Lodgement Number : **LDG-069364-24**  
Case Number: **ABP-318689-23**  
Customer: **Michael Mahon and Regina Hctor**  
Lodgement Date: **18/01/2024 11:28:00**  
Validation Officer: **Daniel O'Connor**  
PA Name: **Tipperary County Council**  
PA Reg Ref: **2360763**  
Case Type: **Normal Planning Appeal PDA2000**  
Lodgement Type: **Observation / Submission**

Tipperary County Council Planning Application Reference Number: 2360763

An Bord Pleanála Case reference: PL92.318689

Description of Development: The construction of 7 no. wind turbines and associated works.

Drawing Title	
Proposed Site Layout	
Project Title	
Carrig Renewables Wind Farm	
Drawn By	Checked By
JF	EM
Project No.	Drawing No.
211016	Fig. 4-1a
Scale	Date
1:32,000	2023-09-21

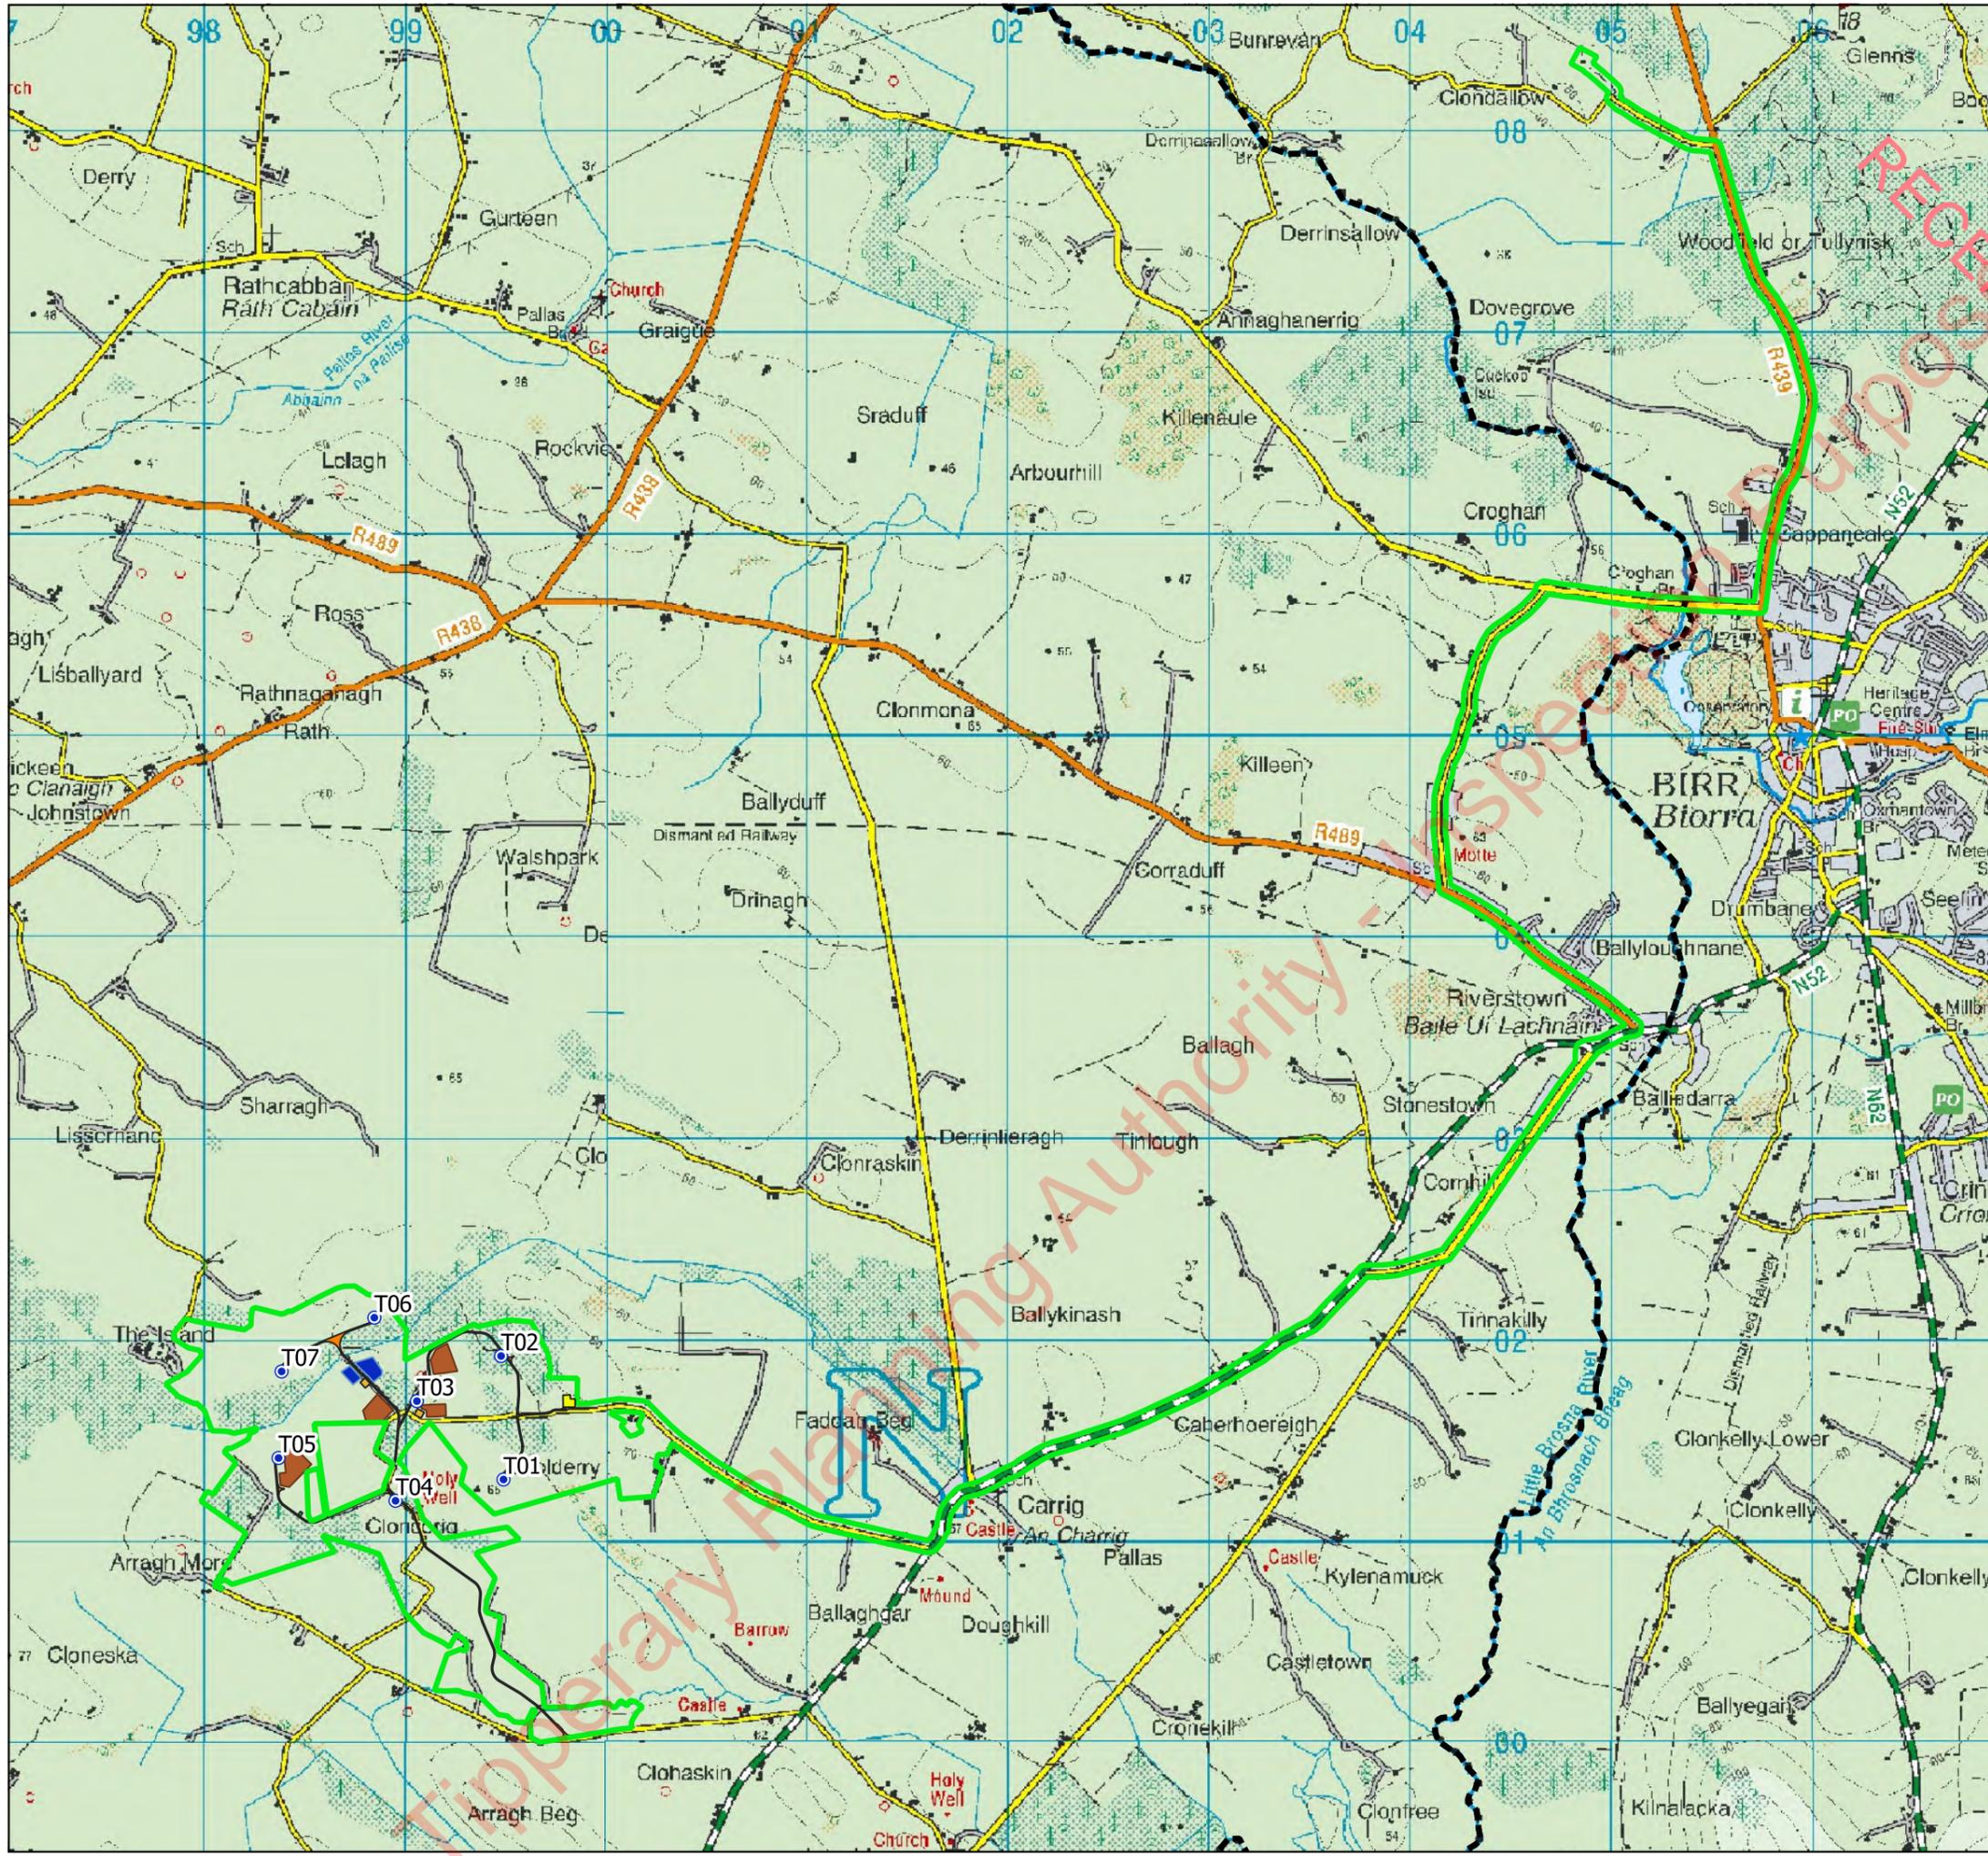
The applicant has supplied setback distances from each household. This is shown with distances and ITM coordinates as reference by their document submission Table 5-8 in "Chapter 5 – Population and Human Beings" in their EIAR submission and locations of wind turbines in drawing pack 1 "Site Layout Plan Sheet 1 of 4". This can be seen in Table 1 below.

However, the measurements applied are flawed on several points. **Firstly, the measurements were taken to the center of the household and not to the nearest point of the curtilage of any residential property.** An example is shown for household 37 in Fig 2, using the ITM coordinates used by the applicant.

If we use coordinates based on the nearest point of curtilage to the center of the wind turbines, then 2 households (37 and 51) are below the minimum setback requirement for a Turbine tip height of the lowest proposed wind Turbine blade tip height of 179.5m x 4 = 718m. A further 4 households (4,14,36,52) are below the minimum setback requirement for a Turbine tip height of the tallest proposed wind turbine blade tip height of 185m x 4 = 740m. See Table 2 for reference.

Secondly, the applicant has incorrectly calculated the horizontal distance required to meet the required set back distance of 4x times the Turbine blade tip height of the proposed wind Turbines. These being between 718m and 740m set back distance.

Taking this into account and based on the nearest point of the turbine structure being the turbine blade, it can be calculated (see Table 3) that the following 11 households (4,5,8,14,36,37,42,44,51,52,18) falls below the minimum separation distance to achieve the setback requirement of 718m and 740m by a significant amount and household 35 falls below the minimum separation distance to achieve the setback requirement of 740m.

In conclusion, the appellants statement regarding compliance to the draft wind energy guidelines 2019 is incorrect. The Appellant in their planning submission have made numerous errors in calculating the required separation distance to meet the minimum setback distance requirement set out by the "Draft Revised Wind Energy Development Guidelines December 2019", to satisfy the visual amenity requirement. They failed to take in to account the curtilage of each household and failed to apply their own calculation used for calculating buffers for other sensitive receptors (Bat Habitats) resulting in miscalculating the distances in their report. The corrected distances using their own calculation results in 4 Turbines T01,02,04 and 05 not meeting the required setback distances as per their proposed application.
